Ribble Valley Borough Council

Date: 24th November 2025

Address: 18 Accrington Road (Former Whalley Motor Services) Whalley BB7 9TD

Proposal: Proposed demolition of former motor services building and construction of new office building.

Drawing Title  
**Proposed Site Plan**

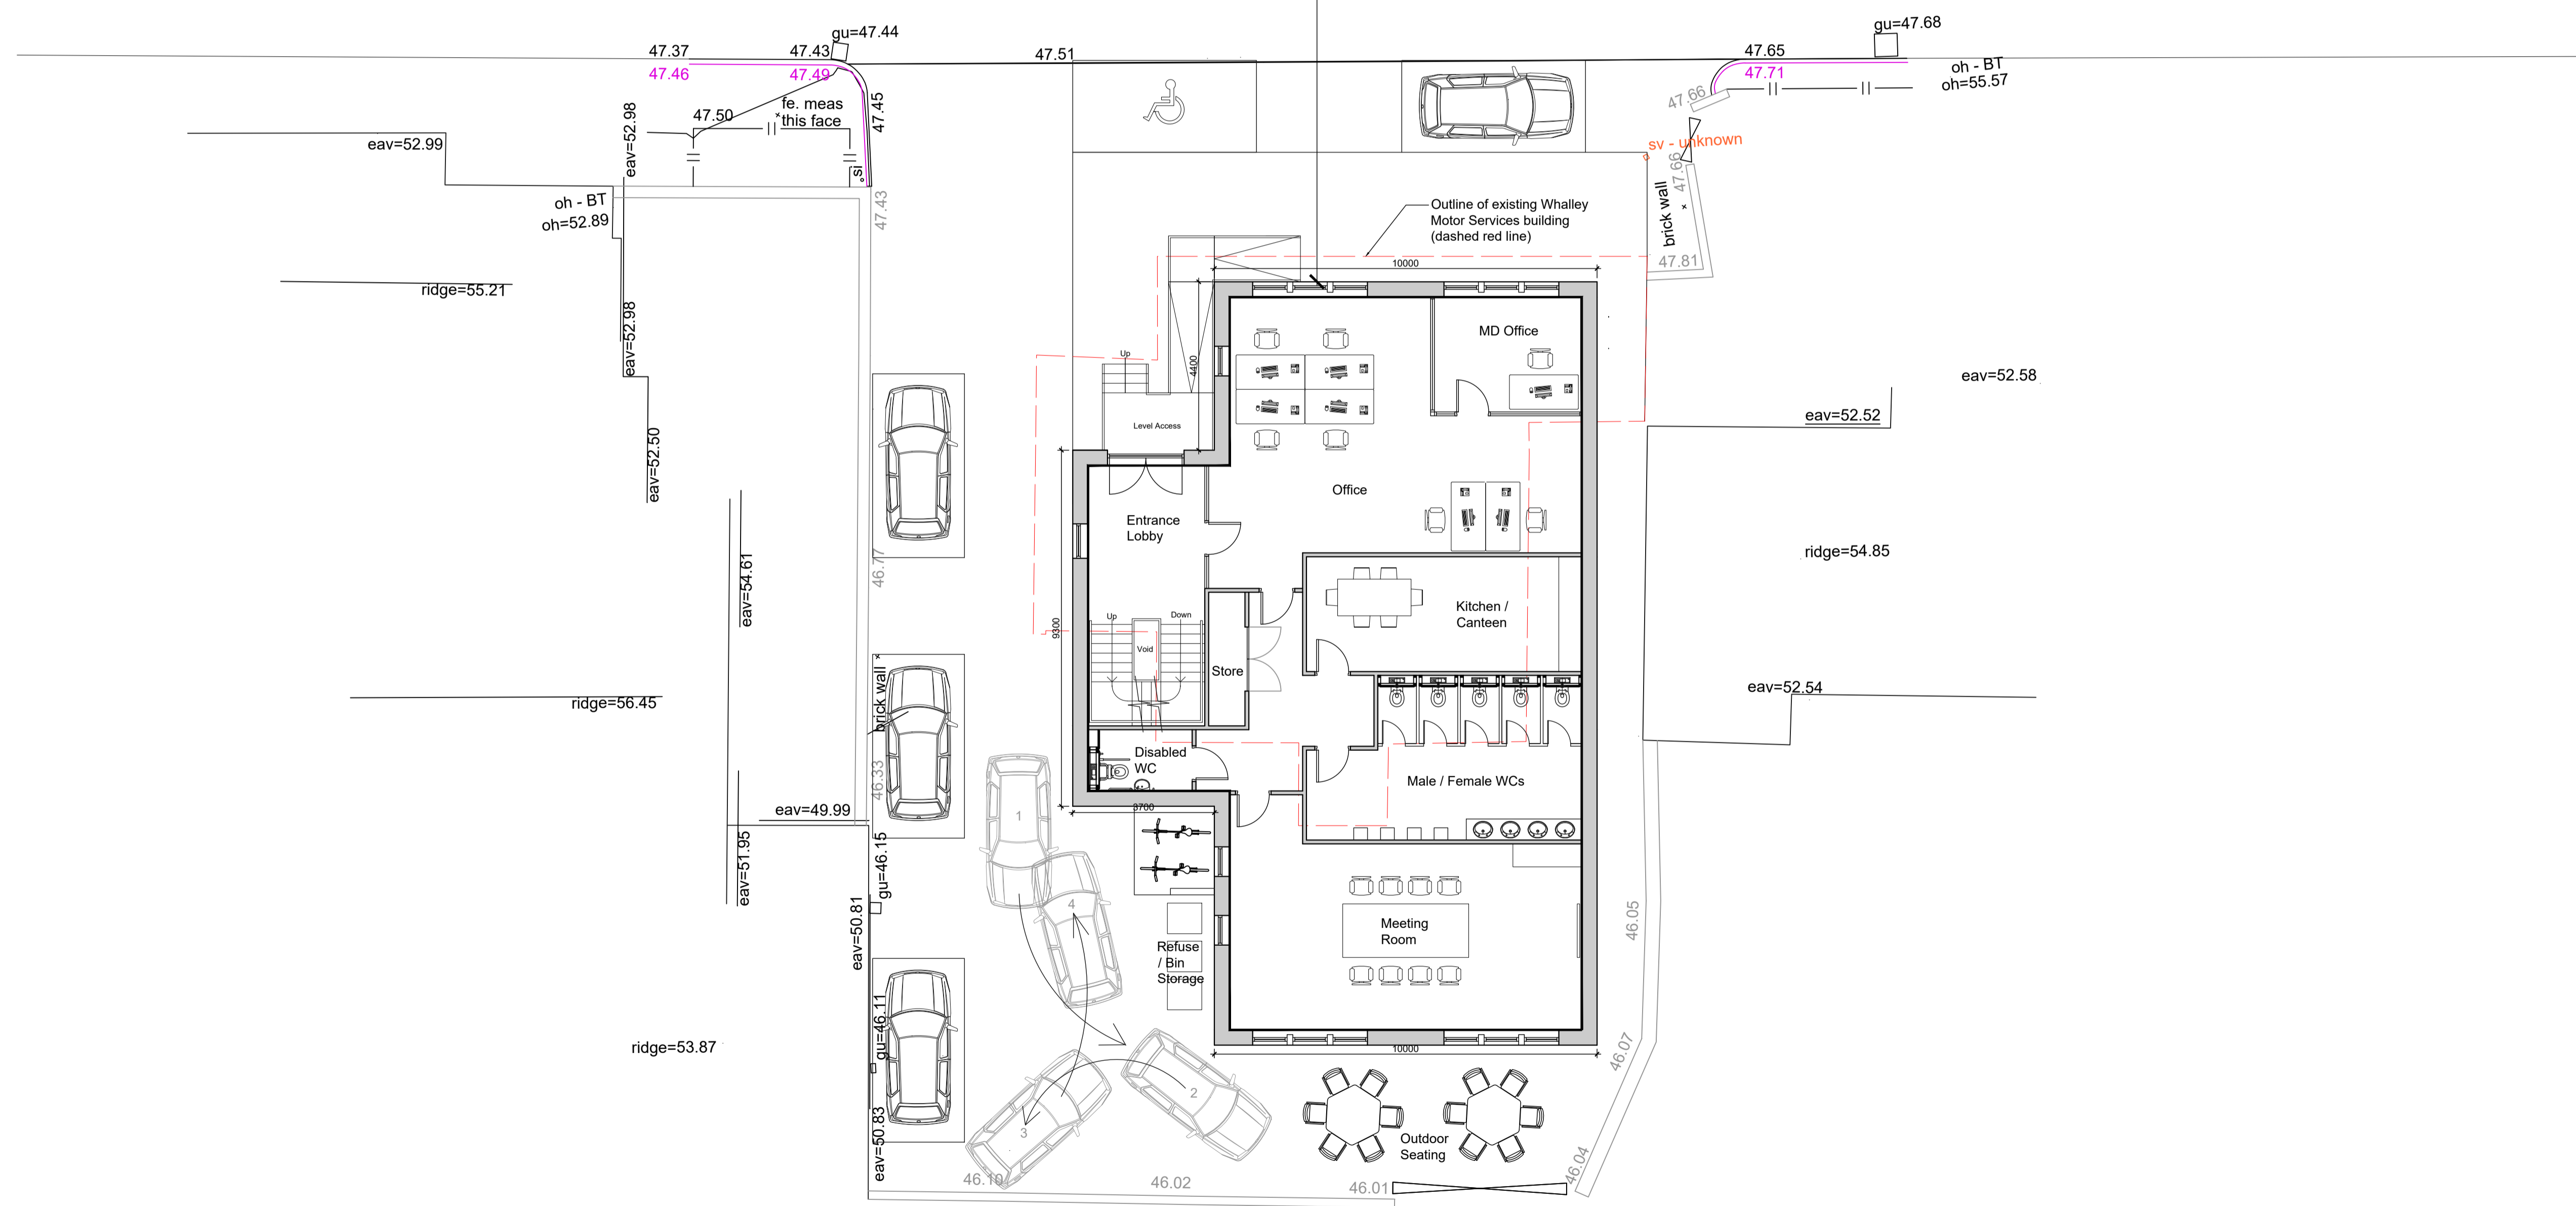
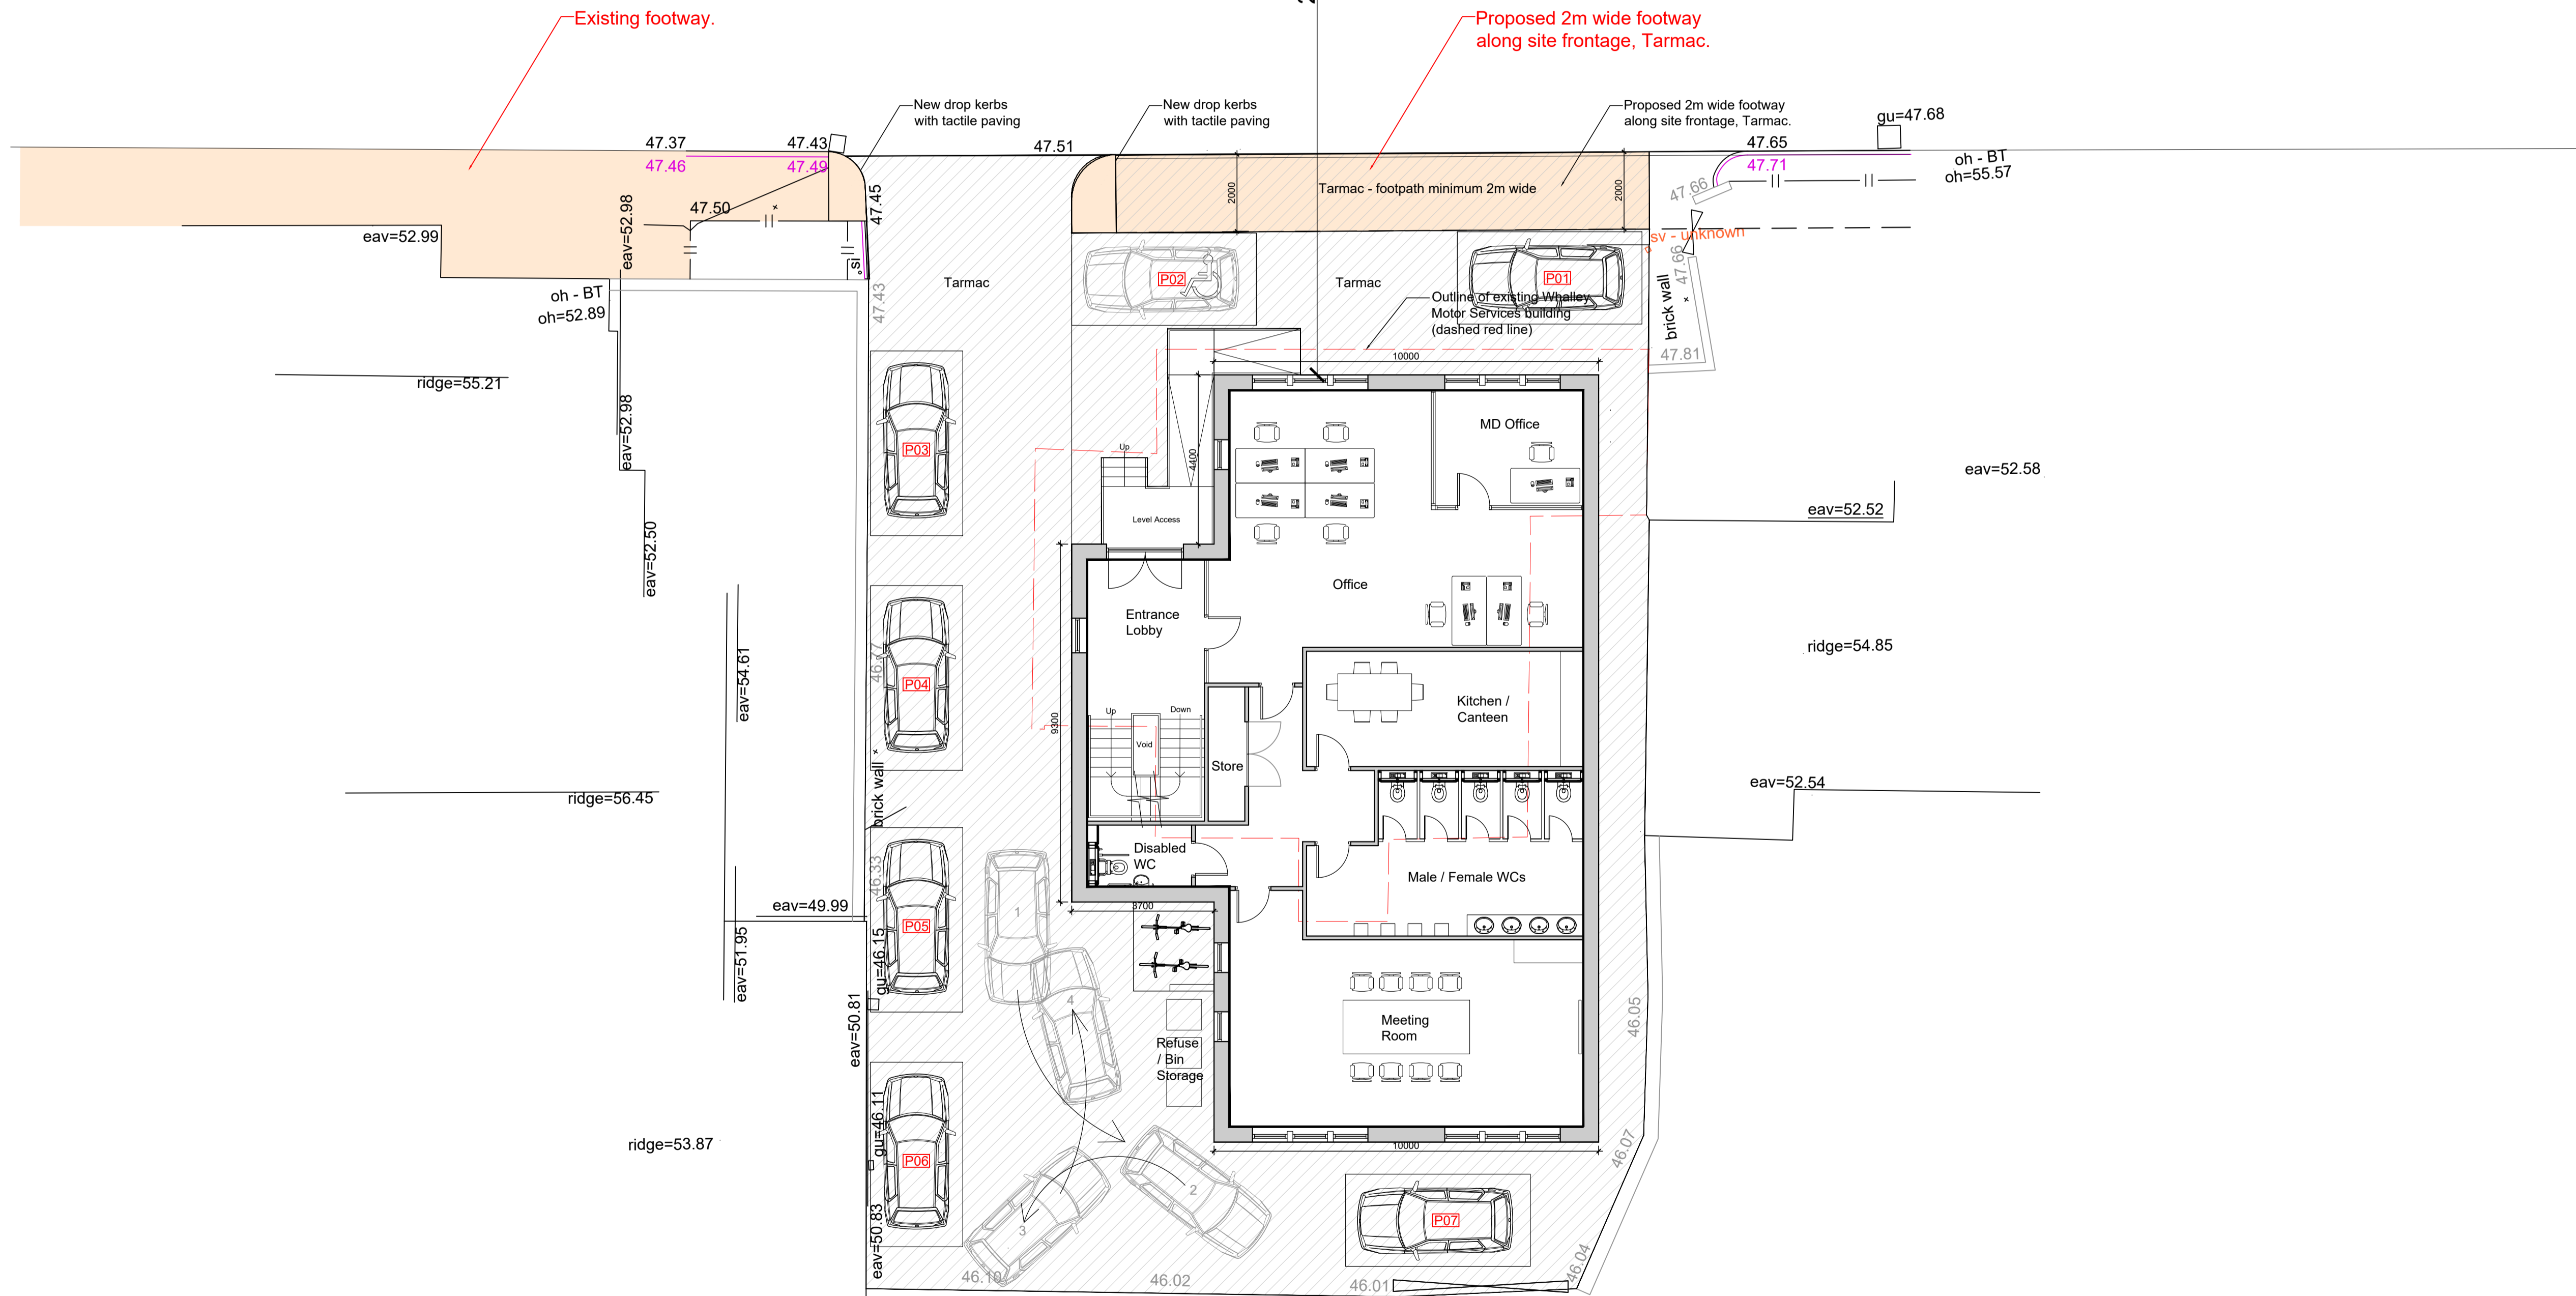
A new footway is considered necessary for this proposal, and we would request that the plans are amended to reflect this. The alterations to the highway will be required to be completed under a S278 agreement with Lancashire County Council.

There are 3 car parking spaces proposed to the side of the premises with space to turn and exit in forward gear which is considered necessary. The 2 spaces to the front elevation would need to be removed to accommodate the new footway.

Lancashire County Council acting as the Highway Authority would request that the footway to the Accrington Road elevation is added to the layout and that the amount of car parking is increased on site and that additional information in form of parking surveys are submitted to demonstrate that there is sufficient on-street car parking available to
